Berry, Huff, McDonald, Milligan Inc.
Engineers, Surveyors

April 18, 2014

RE: Level I-Minor Residential Development Review Site Plan Revisions
Single Family Lot
218 Washington Avenue
Tax Map 10, Block A, Lot 15

These revisions are based on comments from your office dated March 20, 2014. The following is our response to these comments using the same numbering system for clarity:

LEVEL LIP SPREADER

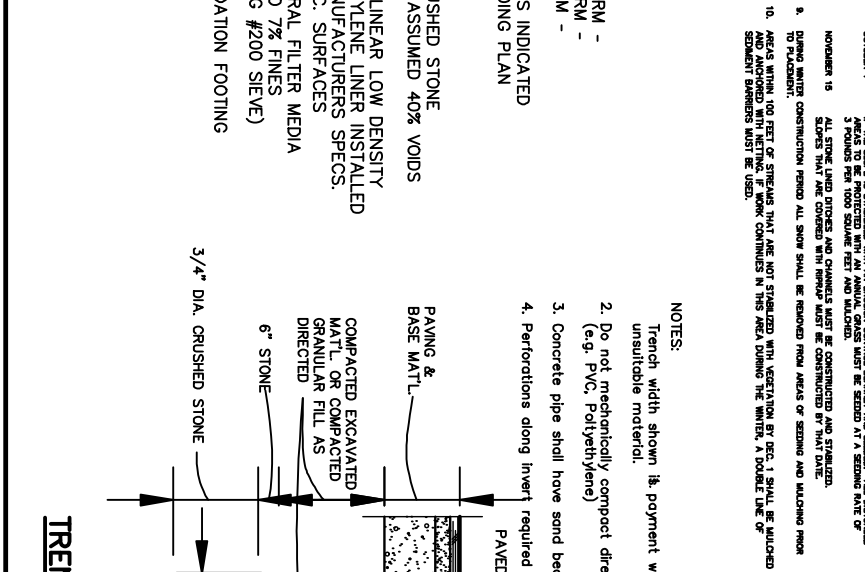
- In order to reduce the possibility of concentrated flows at the foundation drain outlets, there has been a 4' by 8' level spreader added at each of these locations to encourage sheet flow in order to reduce the possibility of erosion and slope failure as requested by the City. A detail of the level spreaders was also been added to the detail sheet (Sheet 2) for your review.

**1** **SITE PLAN**

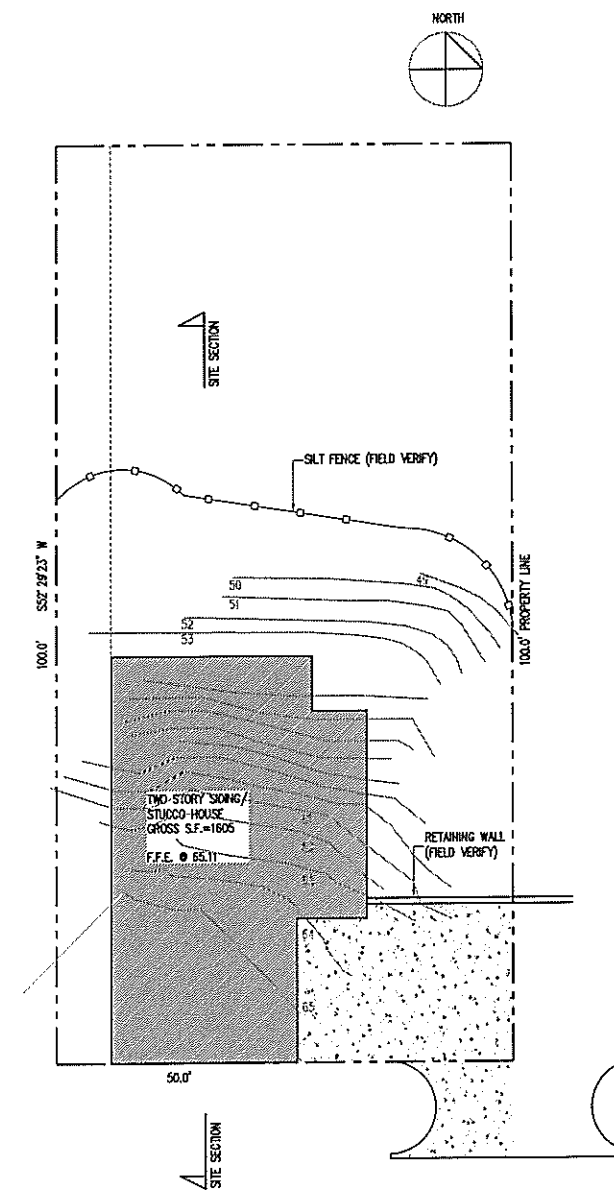
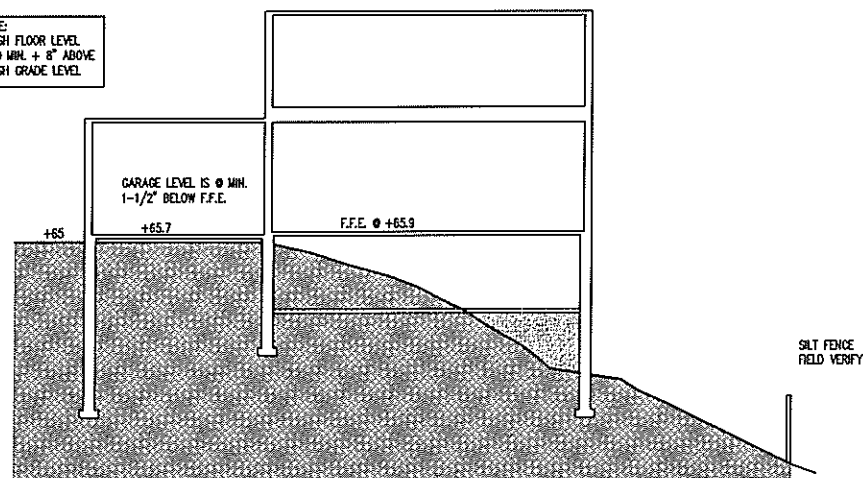
- The side setback on the Southeastern property line has been adjusted to 10 feet as requested. The site design has been revised accordingly.
- Please find attached revised building plans per the applicant's Architect.
